COPPER CHASE AT STERLING RANCH

PRELIMINARY UTILITIES

MAY 2023

## PRELIMINARY UTILITIES

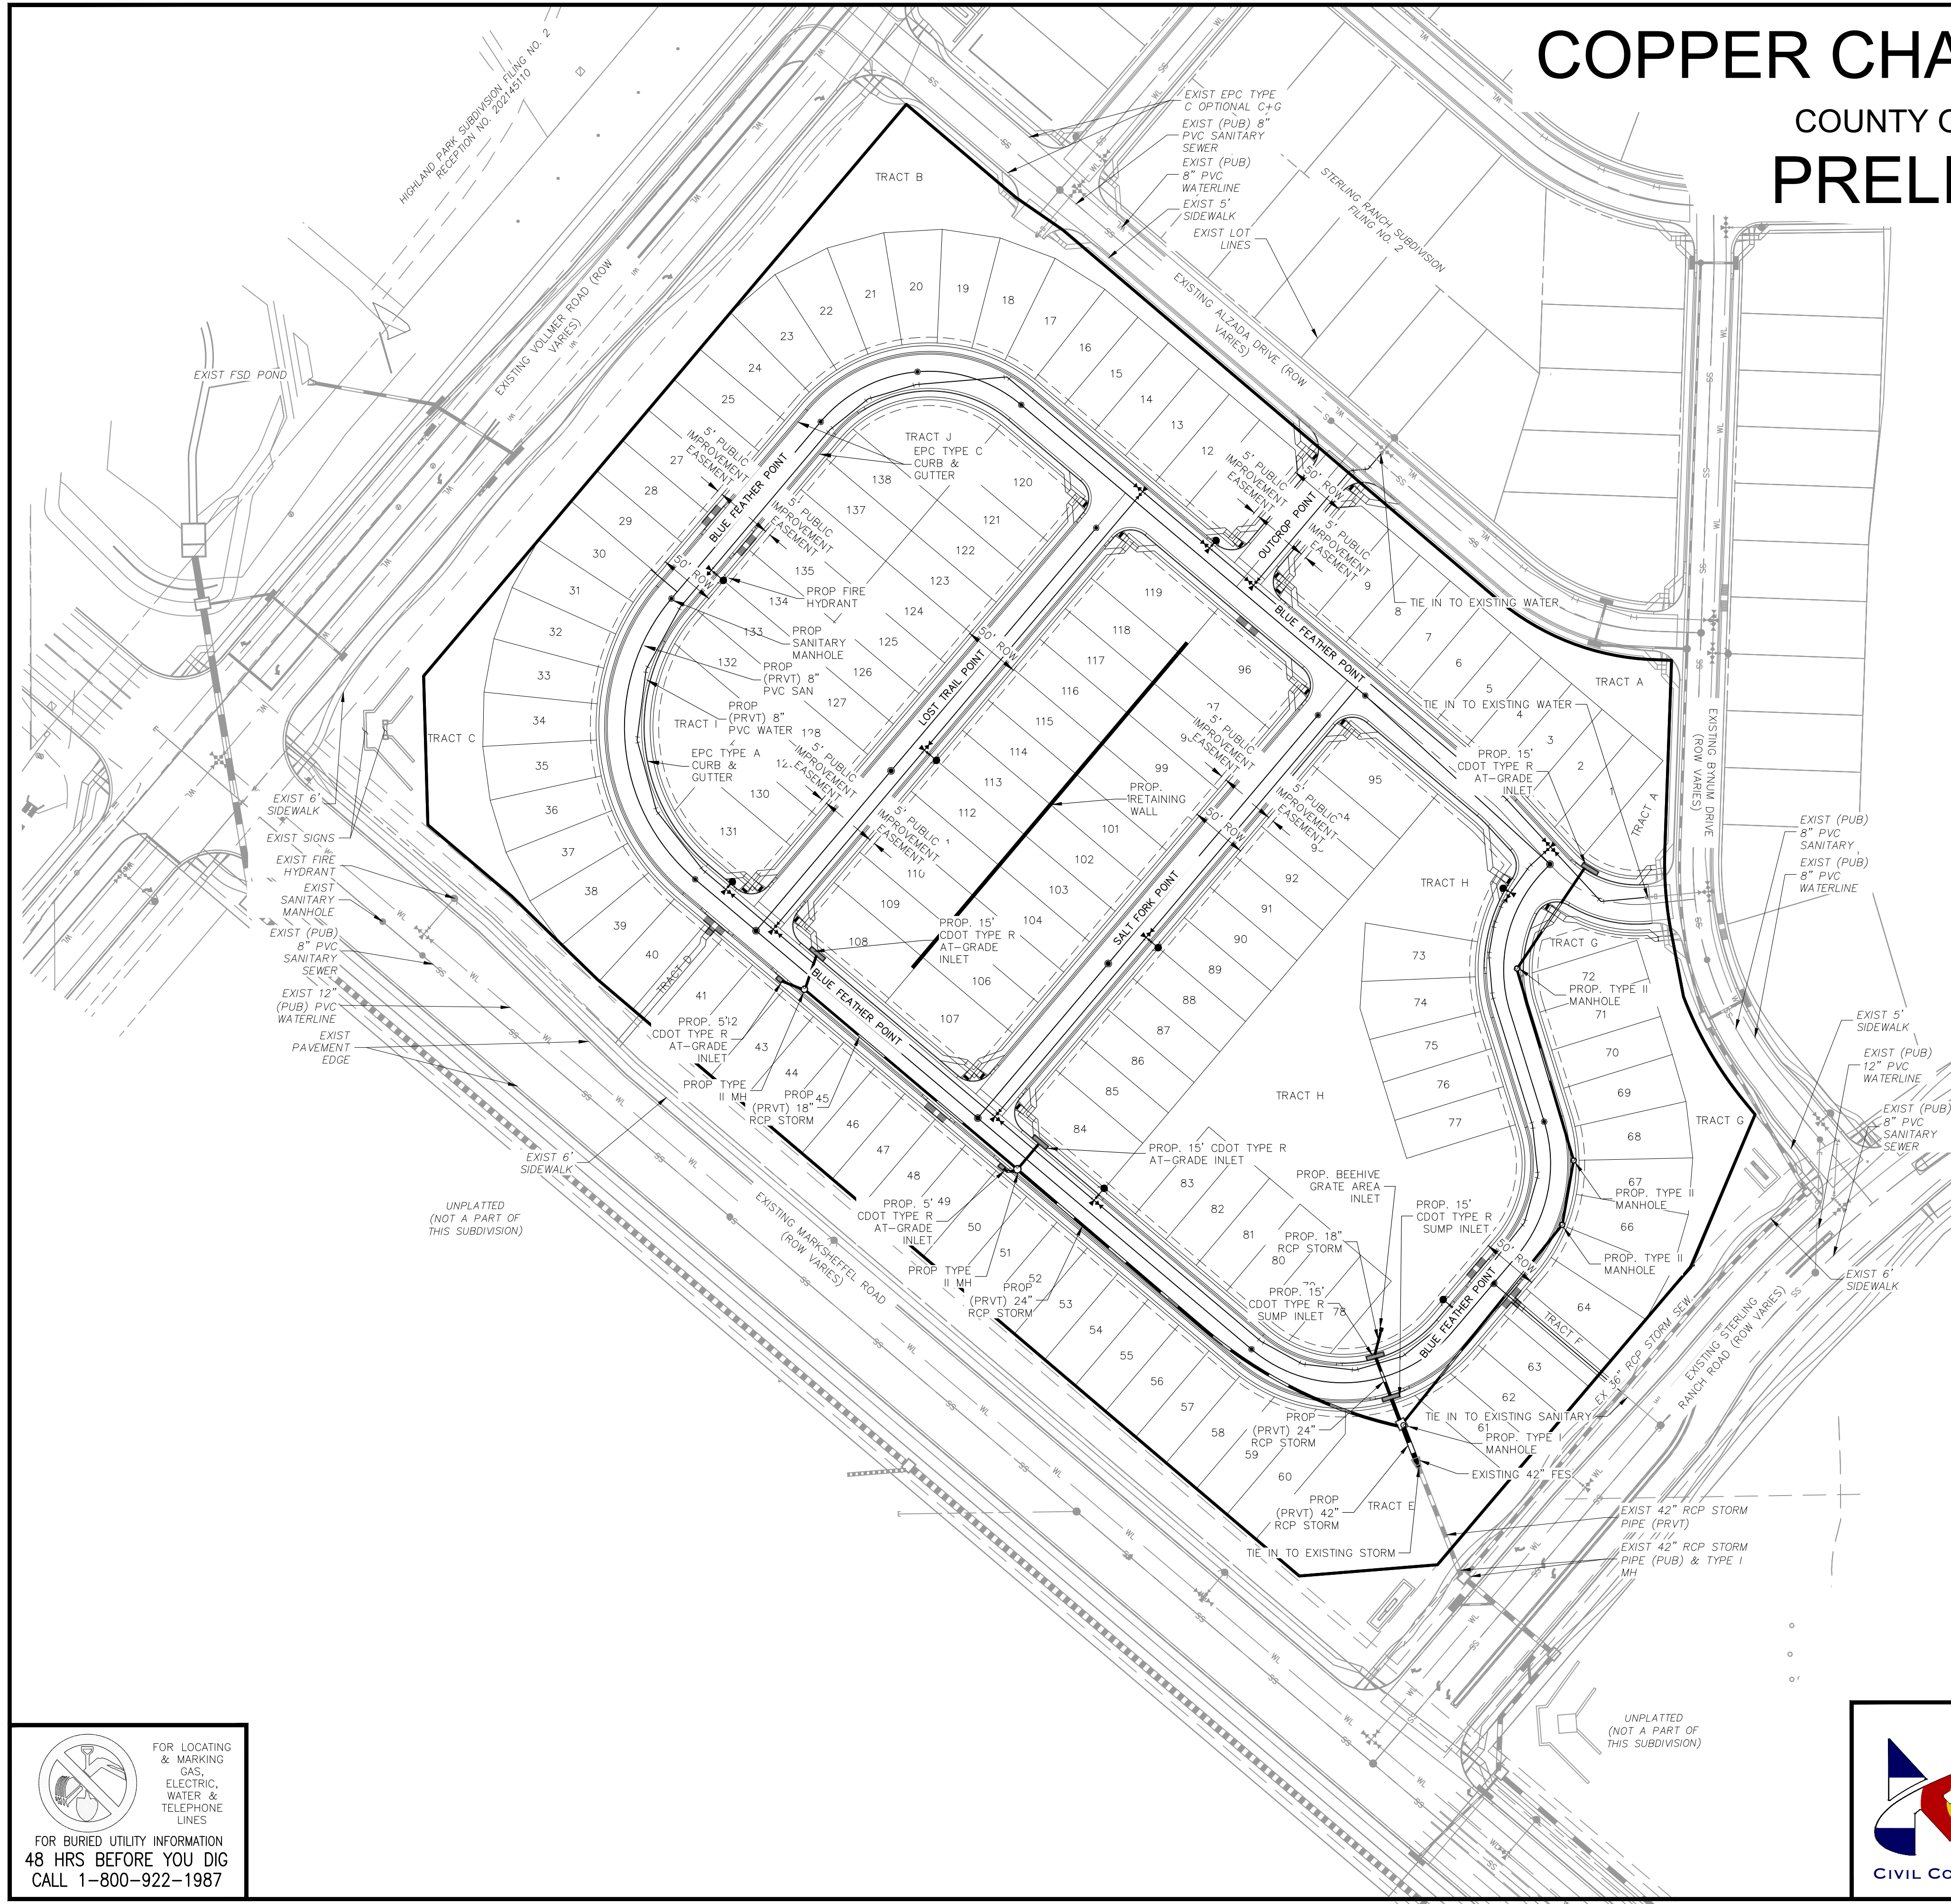
See comment response from MS. Would we resolve this. I will look for MVEA responses regarding cutting into their easements.

10' WIDE EASEMENTS OVER LOT 60 AND 61 HAVE BEEN ADDED. EASEMENTS ARE NOT NECESSARY OVER TRACTS AS THESE ARE DEDICATED FOR DRAINAGE
